Commitment Letter

Project Name: Rapson Subdivision

Description: Rapson Subdivision is being proposed with two residential lots that is located southeast of Hardy Road and Black Squirrel Road in Section 14, Township 11 South, Range 65 West.

SHEET 2: boundary and plat detailed information

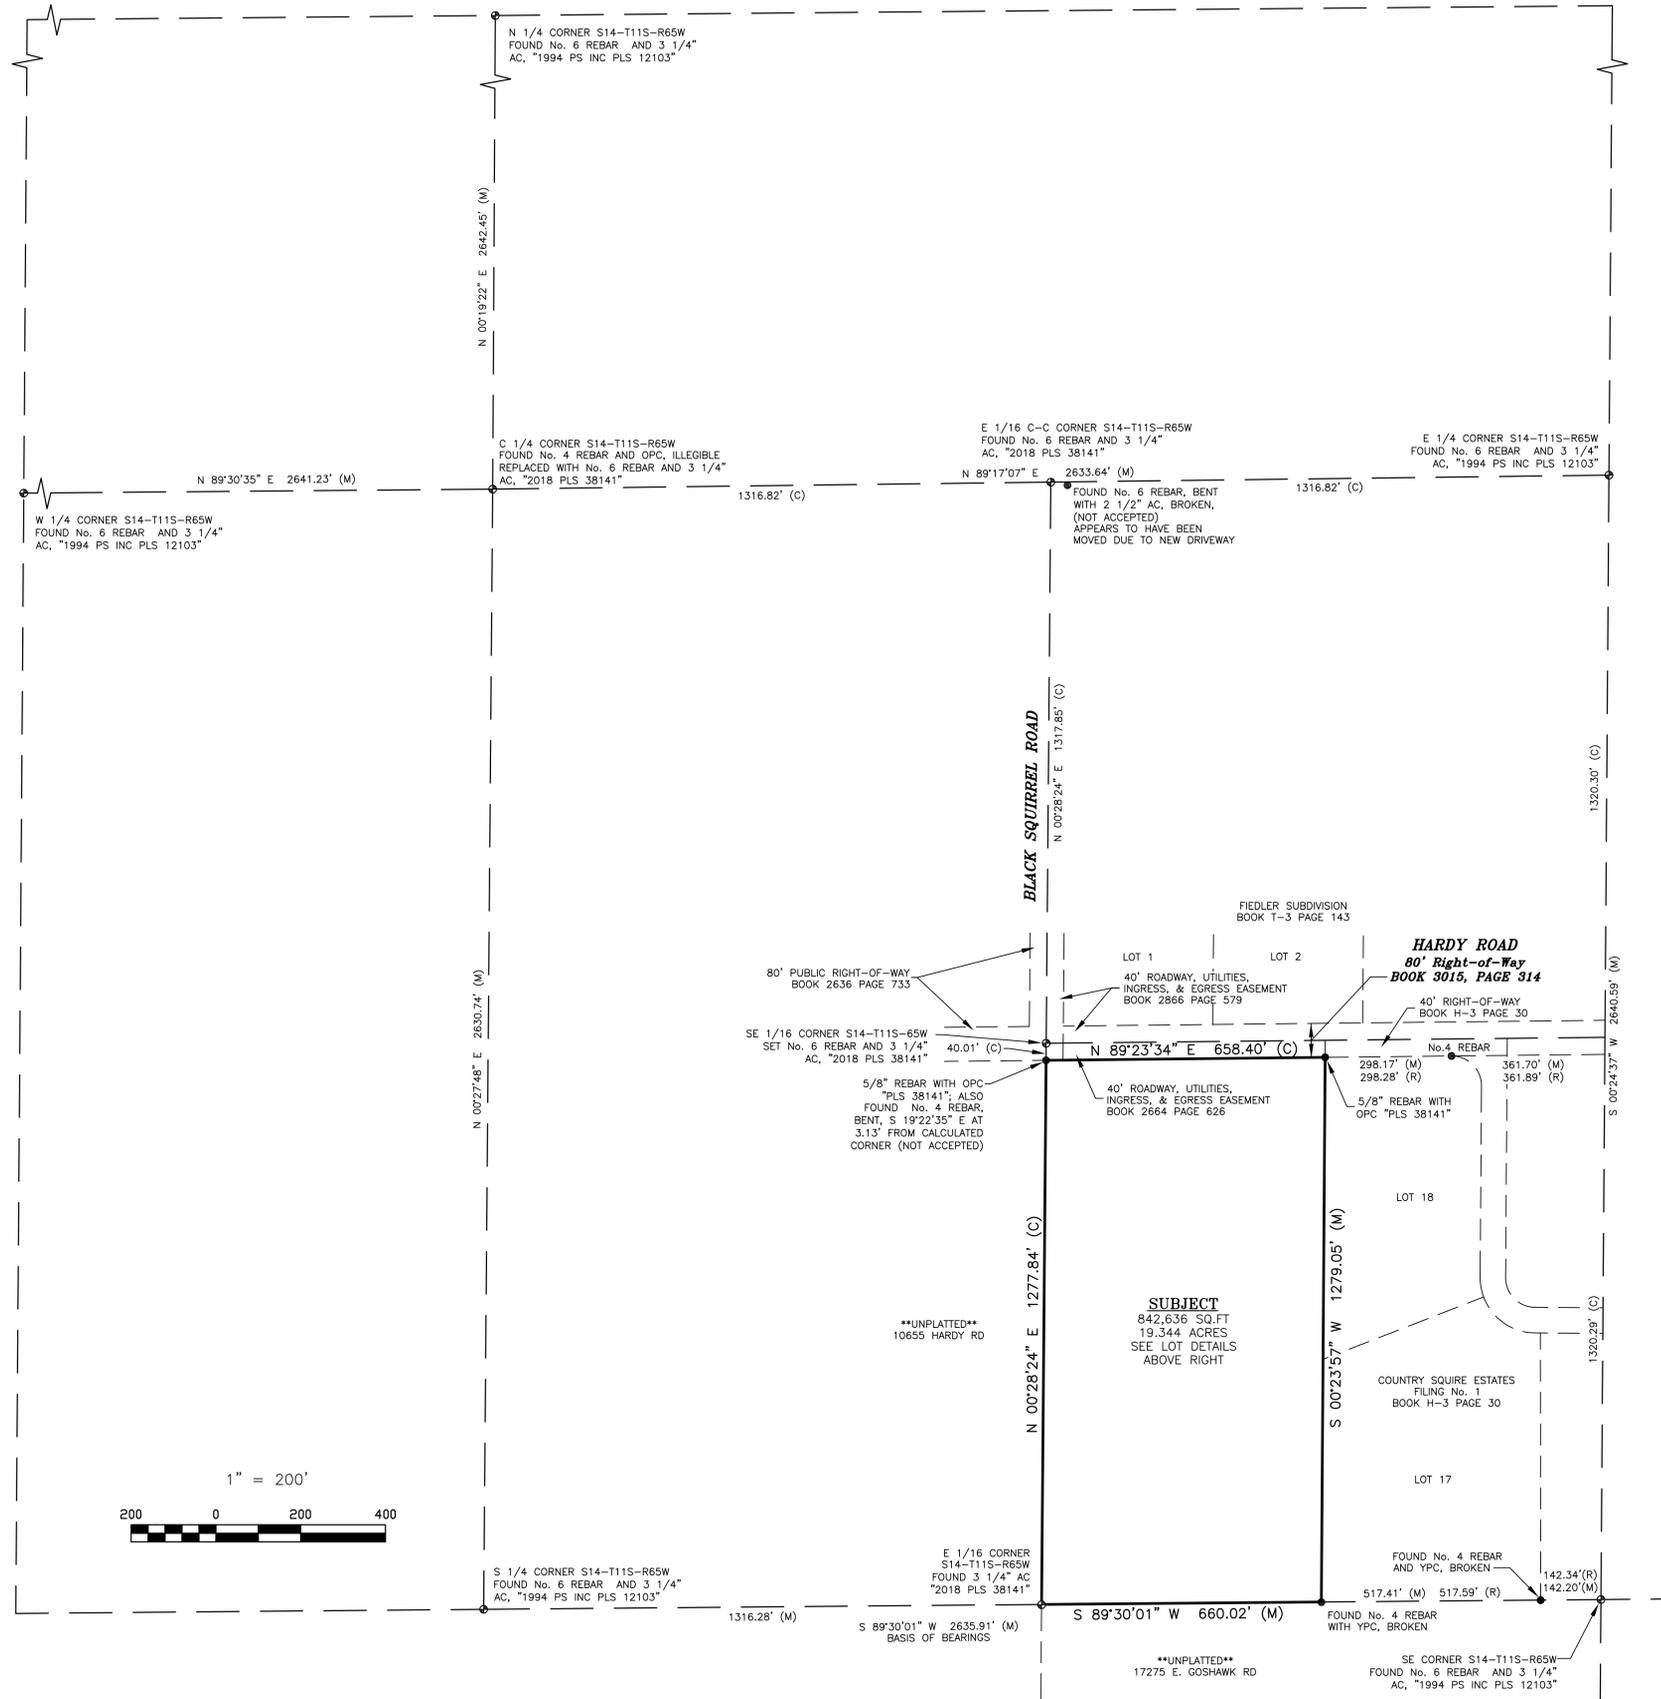
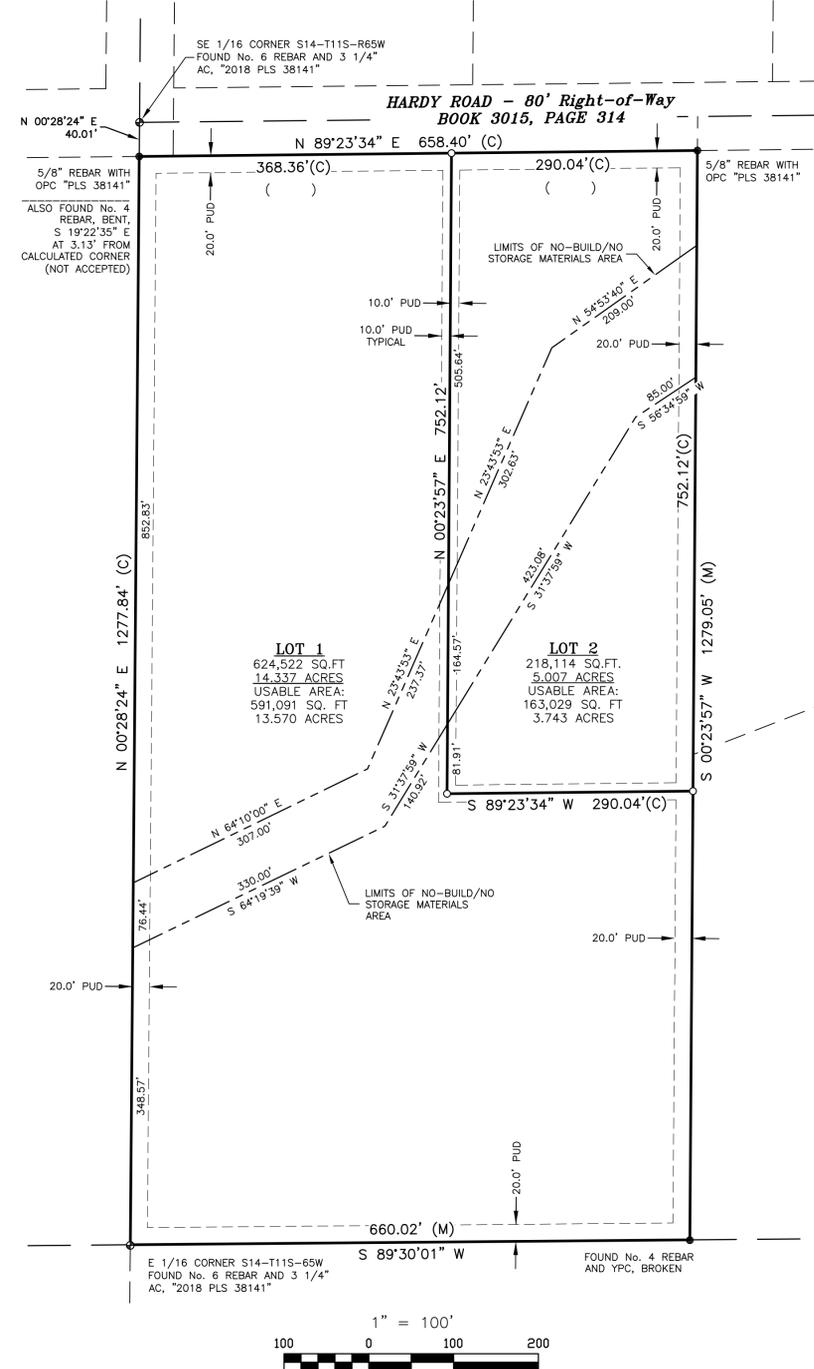
MVEA requests a ten (10) foot common lot line utility easement along with a twenty (20) foot exterior subdivision utility easement. MVEA also requests platting of existing MVEA facilities with easement on the plat. Additional easements may be required.
